From: Lewis, Trevor [Trevor.Lewis@lancashire.gov.uk]

Subject: 3/2012/1096 Downham

Trevor Lewis
Traffic and Development Engineer
Highways District Office (Ribbles Valley and Pendle)
Lancashire County Council;
01282 475583
www.lancashire.gov.uk.

FRONT CARPARK PLAN
PROPOSED

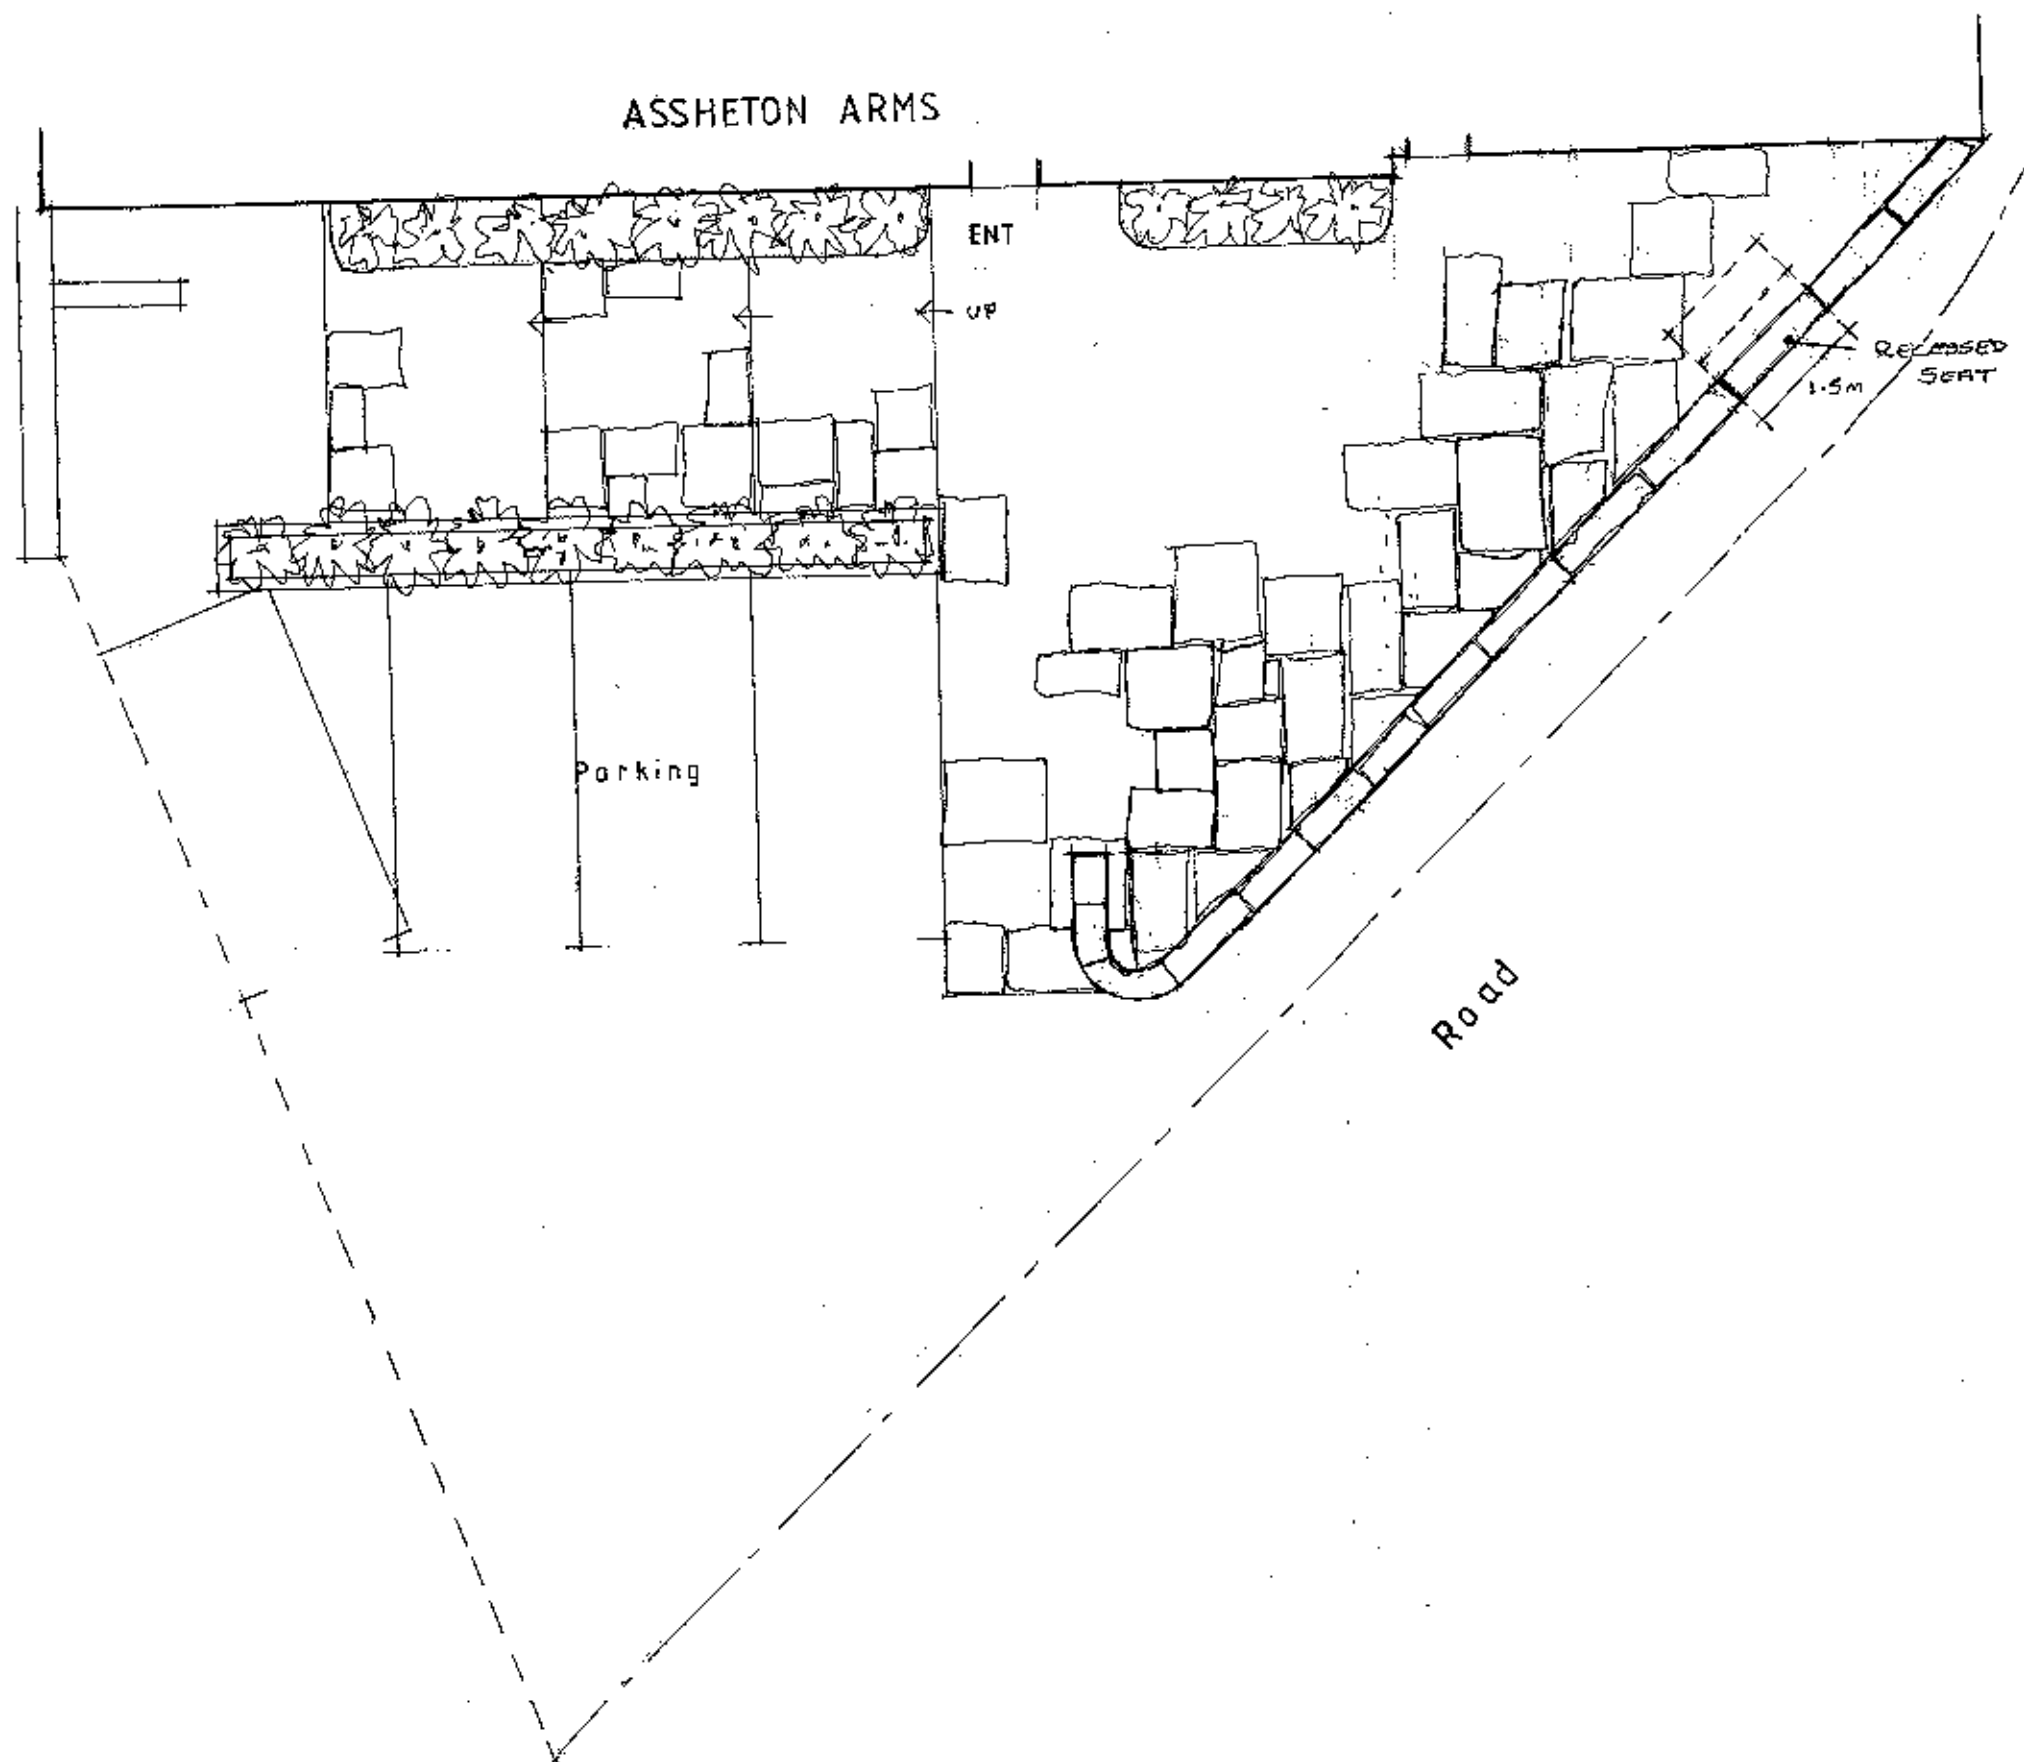
As discussed today, I would not insist on the normal bold white lines to mark out the parking within the pub forecourt as suggested in the application. If you consider it appropriate, some other form of demarcation, such as setts in the bitmac, or short lengths of white lining marking the ends of the car park, could be used.
